From: Bloomer, David <David.Bloomer@lancashire.gov.uk>
Sent: 01 May 2018 12:02
To: Rebecca Bowers
Cc: LHS Customer Service; planning; Lancaster, Jason
Subject: app3/2018/0304 Land East of Chipping Lane

Dave Bloomer
Development Control
Lancashire County Council

Title
TEMPORARY SALES AREA

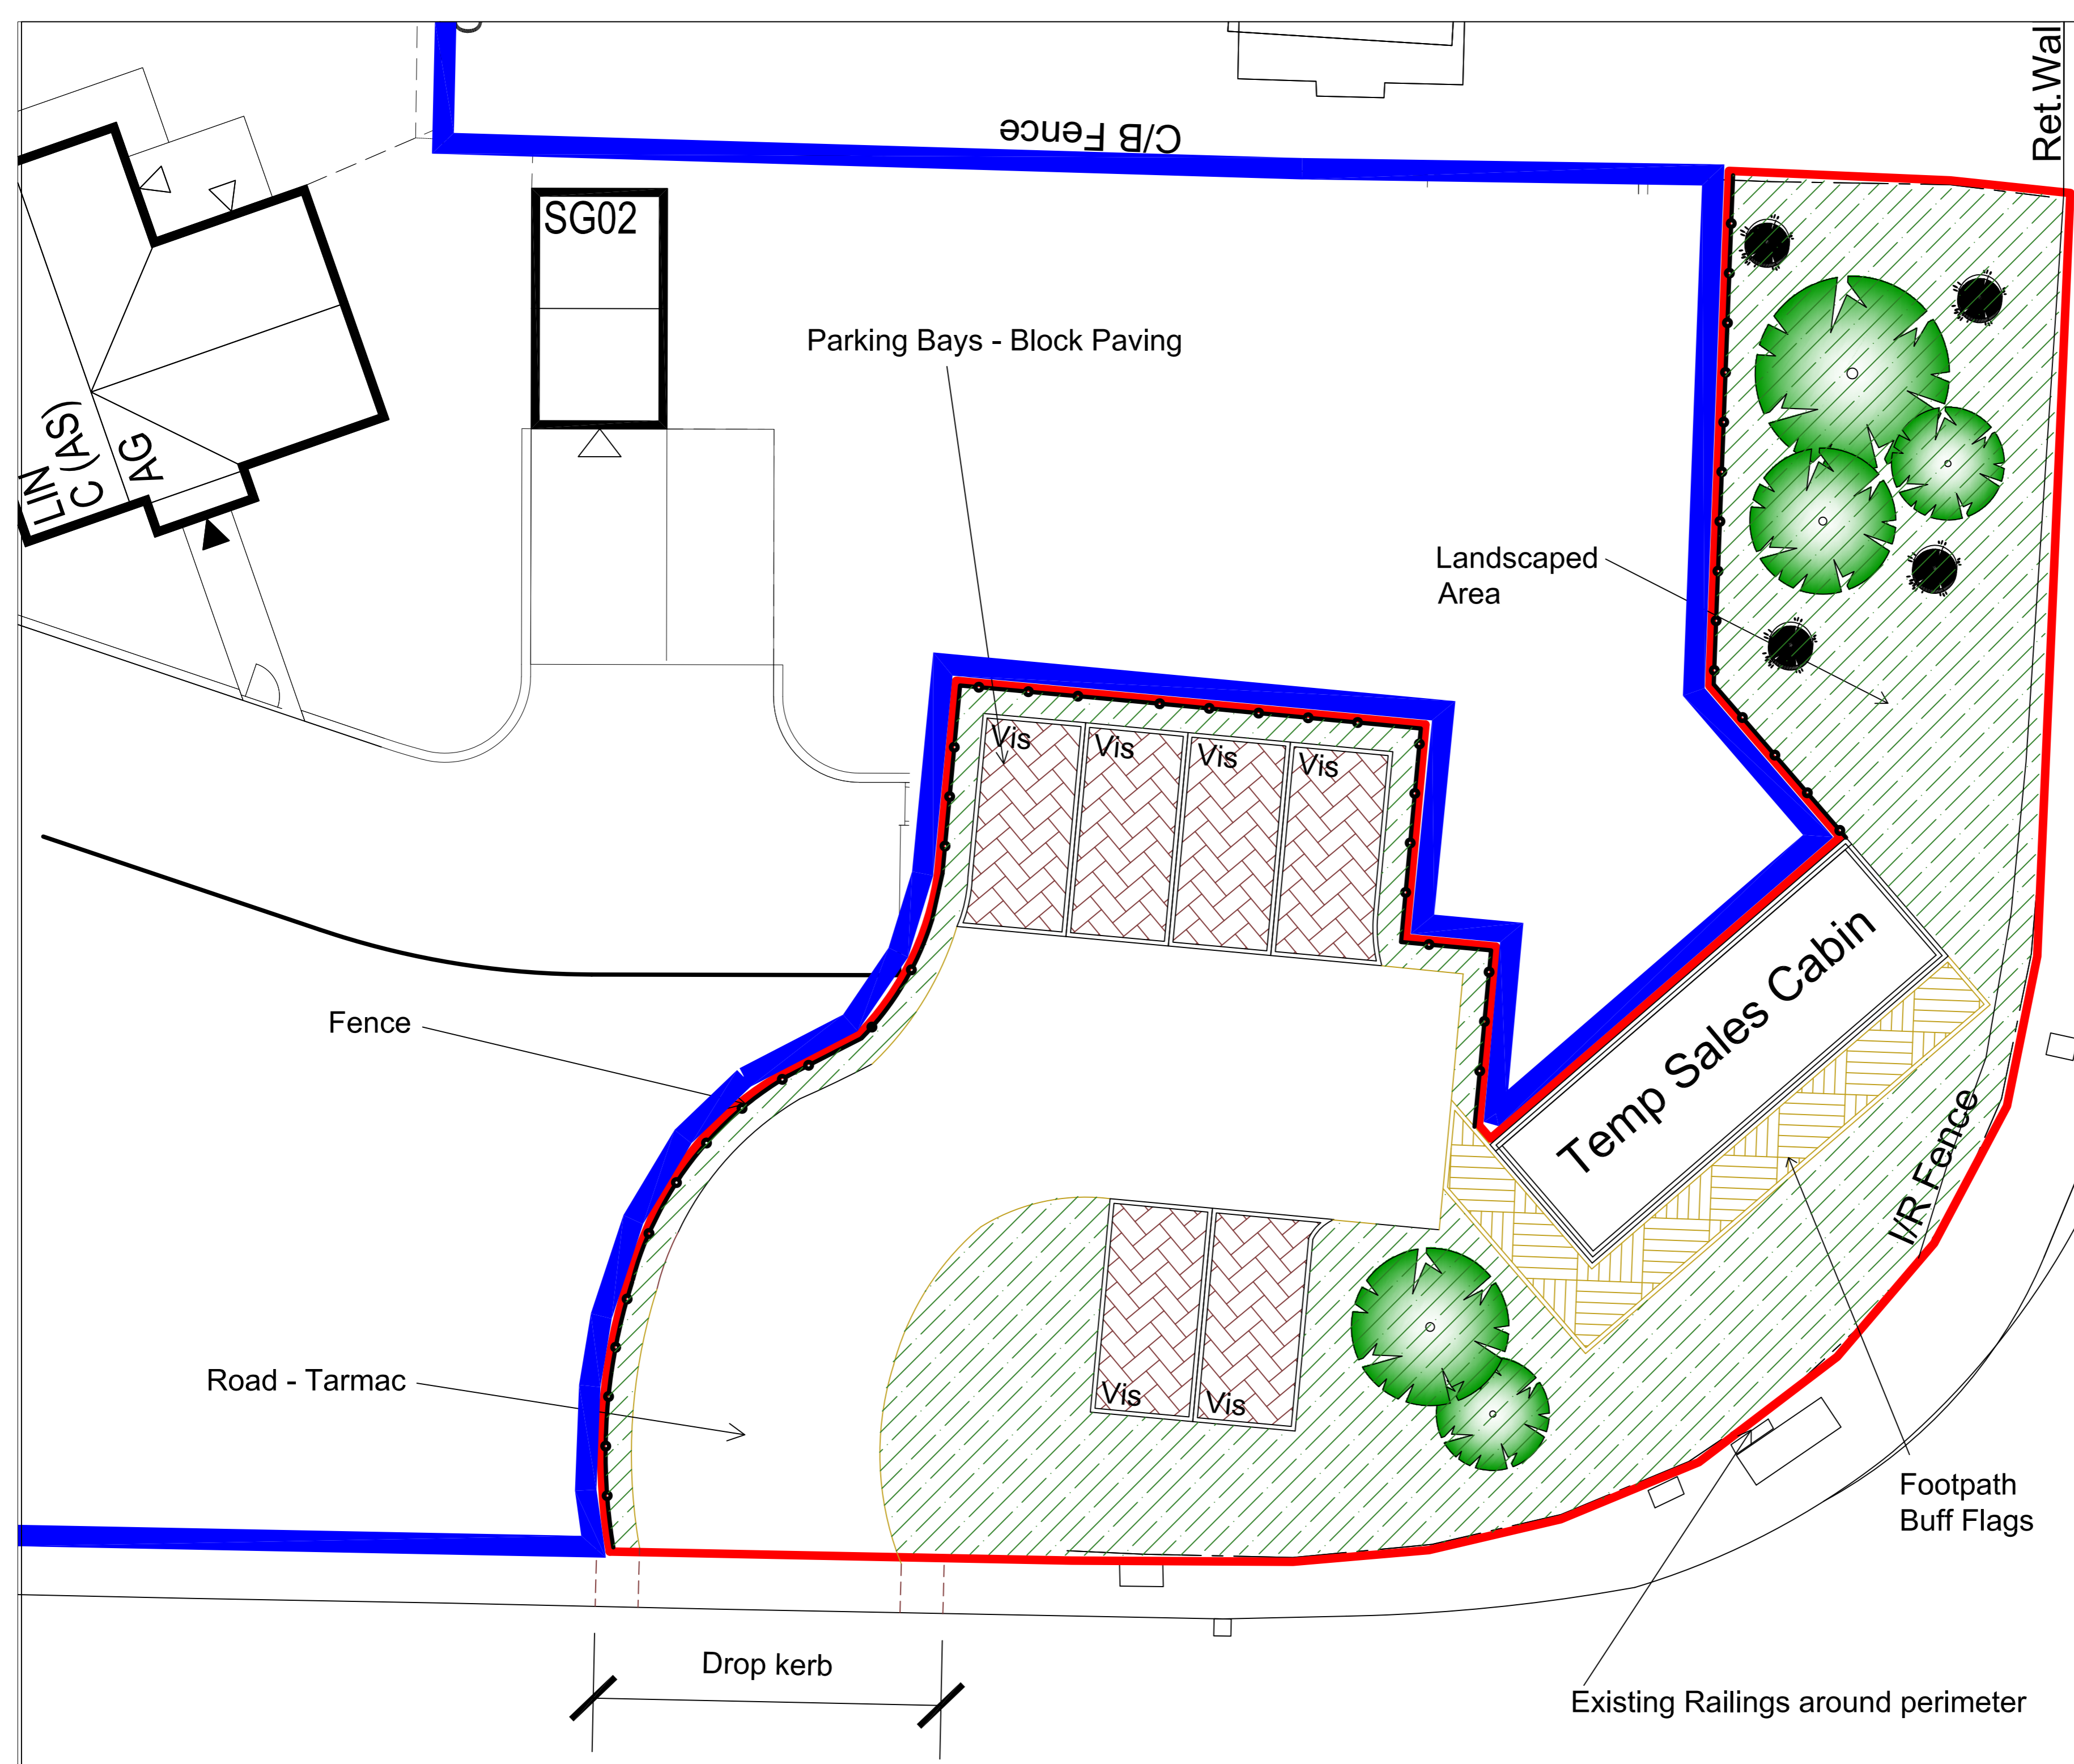
From a highway perspective , a vehicle access has previously been created at this location which did not have a properly constructed vehicle access crossing and as a result I believe that enforcement action was taken and the access closed. At the time, it was made clear that the proposed access would not be acceptable, should a planning application be subsequently permitted, due to its proximity to the bend in the road and junction with Inglewhite Road and the pub access across the road. It also transpires that as a result of the closure of this illegal access the police became involved as visitors were resorting to parking on Chipping Lane / Inglewhite Road which gave rise to safety concerns due to the prevailing highway conditions.

There is nothing to suggest that this position has changed and I would therefore have to recommend that the element of the application for the vehicles access crossing should be refused on highway safety grounds. If the sales cabin is to be retained at its current location then all vehicular access should be taken from within the main site and there should be no direct pedestrian access to the sales cabin from either Chipping Lane or Inglewhite Road. A high fence will need to be erected to prevent any such access.
